**From:** Neville, Julie [REDACTED]  
**Sent:** 08 August 2025 14:50  
**To:** Planning  
**Cc:** Holt, Kelly  
**Subject:** Reserved Matters 3/2022/0317, Land at Higher Standen Farm and Part Littlemoor Farm Clitheroe  
**Attachments:** 3 2022 0317 Overlay 1.pdf

Reference 3/2022/0317  
Location Land at Higher Standen Farm and Part Littlemoor Farm Clitheroe  
Proposal Reserved Matters application in respect of Phase 5 and 6 to include access, appearance, landscaping, layout and scale with respect to 265 dwellings following outline approval 3/2015/0895.

Client:	
Project Title:	
Residential Development	
Address:	
Higher Standen Farm, Clitheroe	
Drawing Title:	
Proposed Composite Layout Phase 6	
Drawing No:	
TW/HSF/PLP6/01	
Dwn: BDC	Ckd: ST
Date:	28/01/22
Scale:	Paper Size:
1:500	A1
	Rev: B

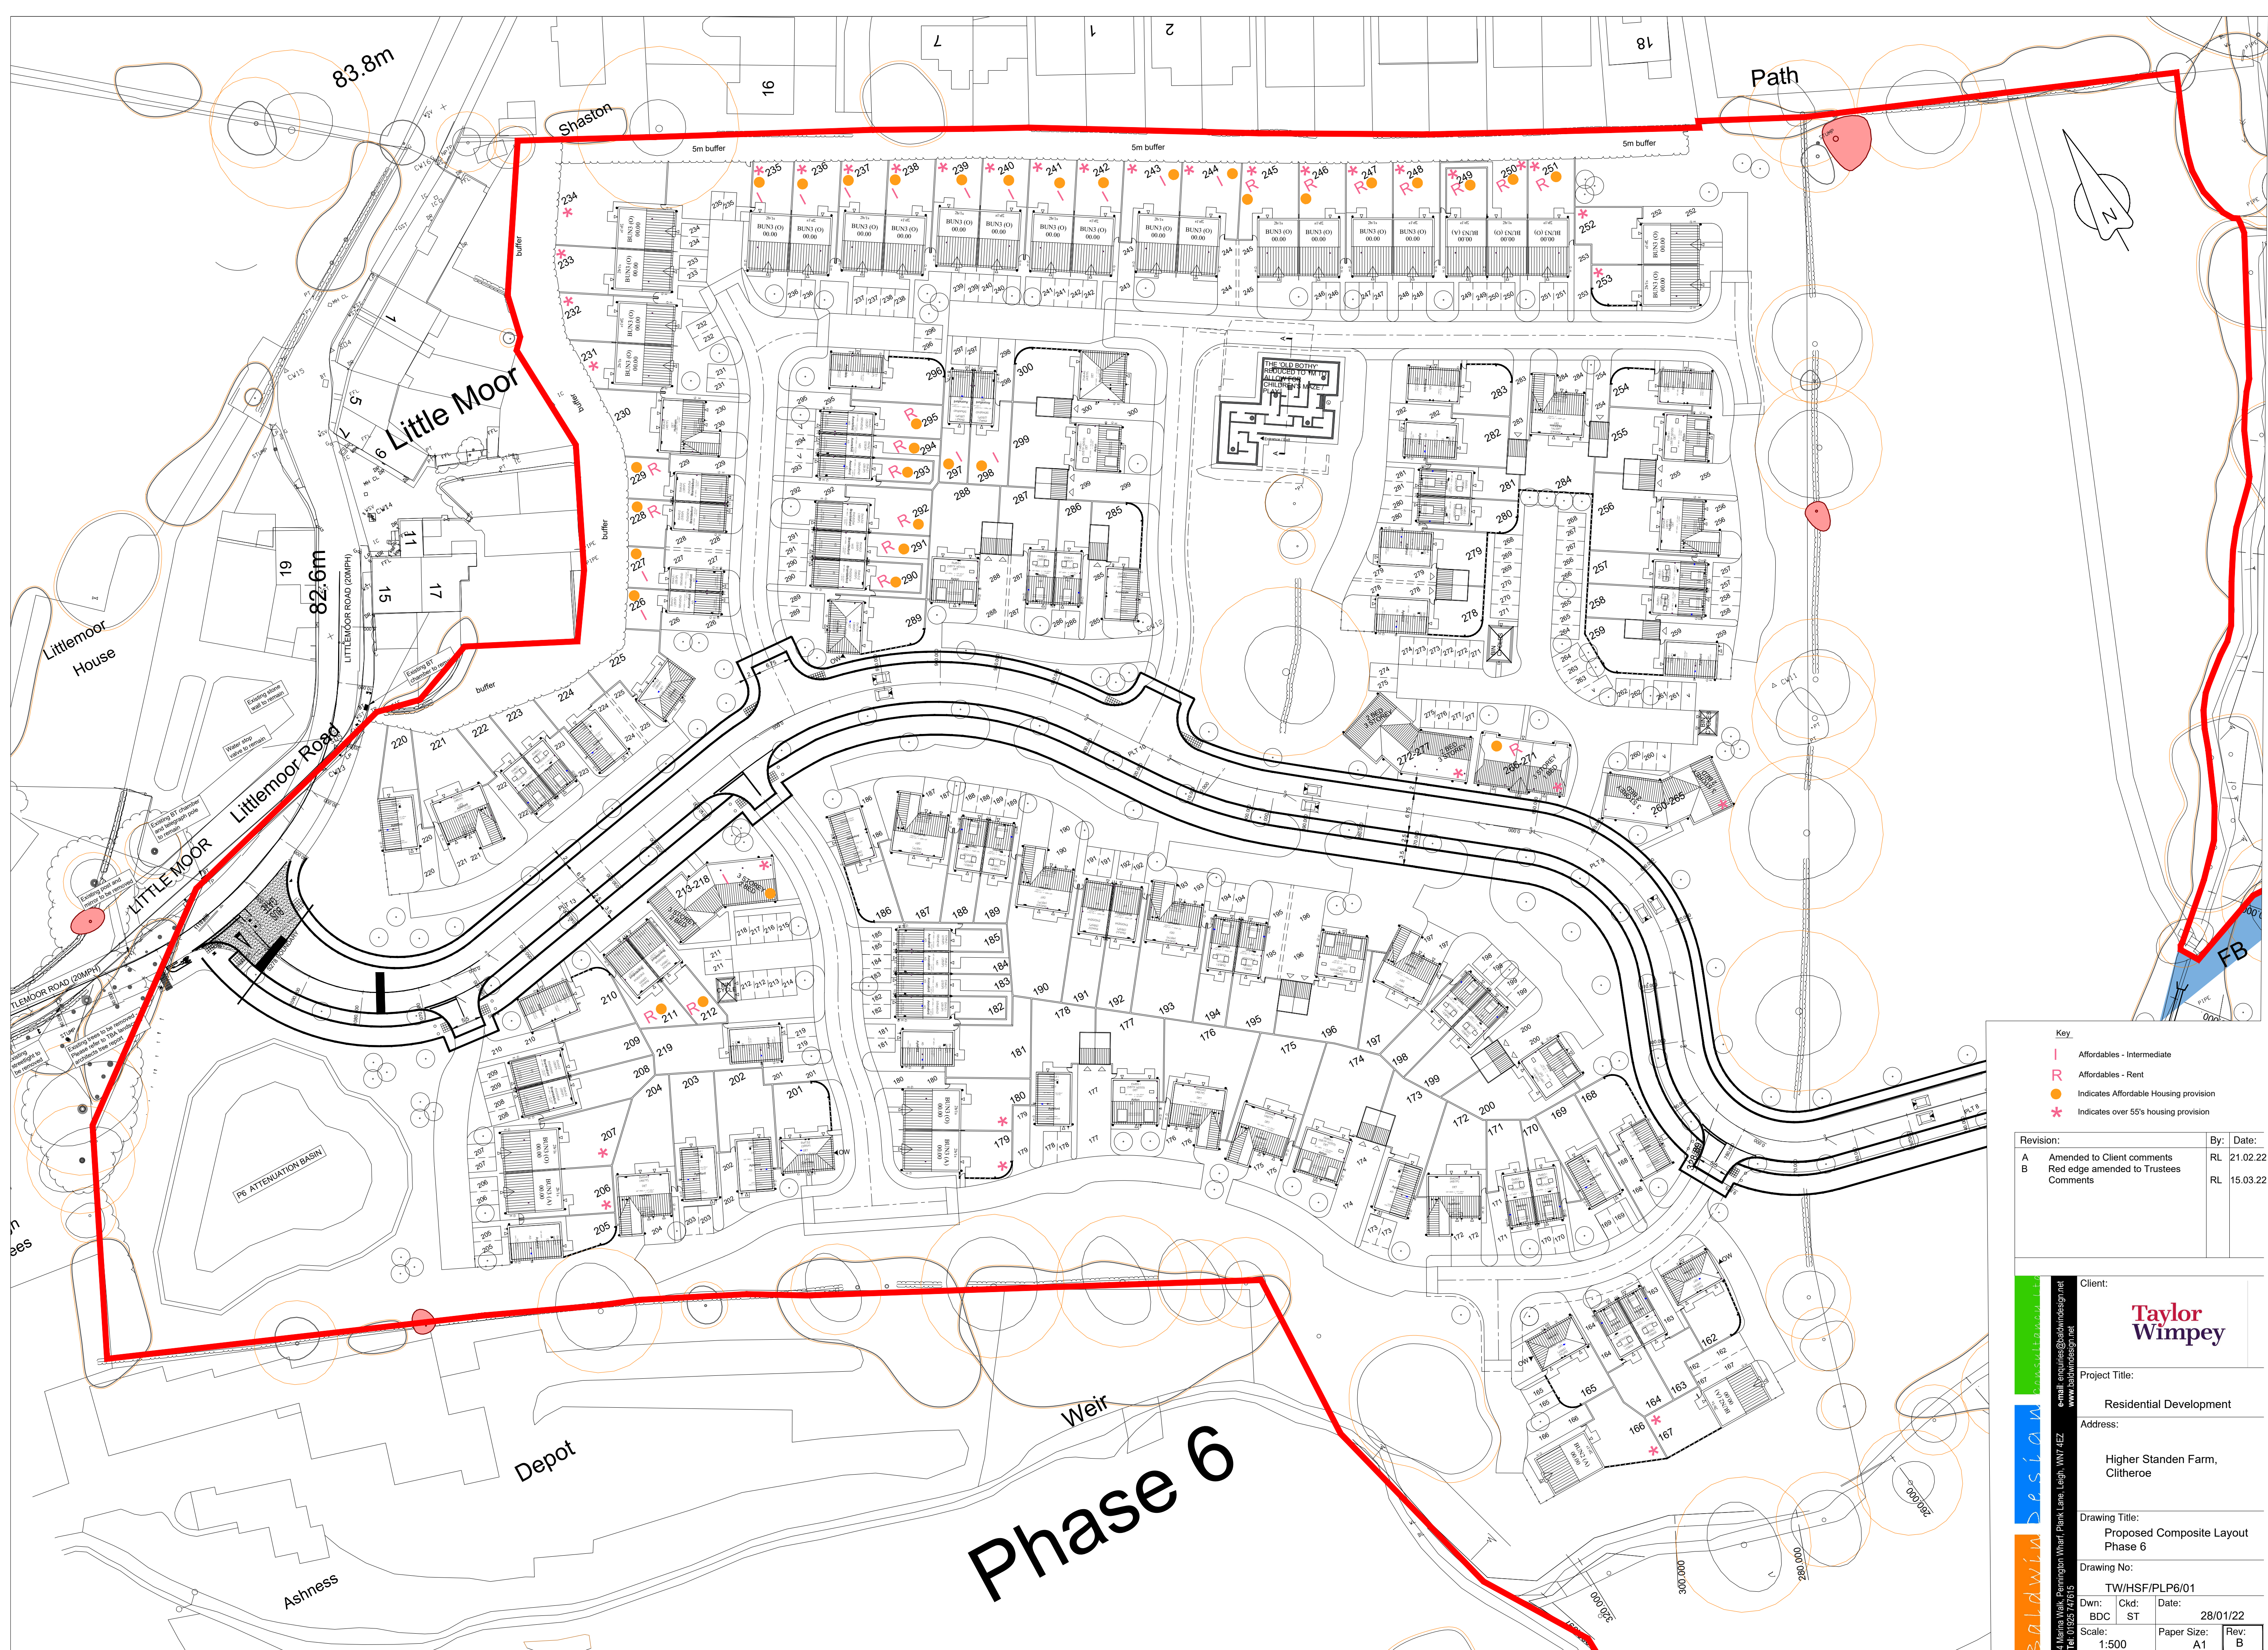
The landscape plan (sheet 4) shows there to be planting and a play area that will obstruct footpath FP0301014, however the play area is excluded from the layout plan. The public Rights of Way Team request clarification on the inclusion of the play area and the mitigation measures to protect the definitive line of the footpath. Further details are also requested for the replacement of the pedestrian footbridge and the replacement of infrastructure on the boundary of the development, if still necessary for stock control.
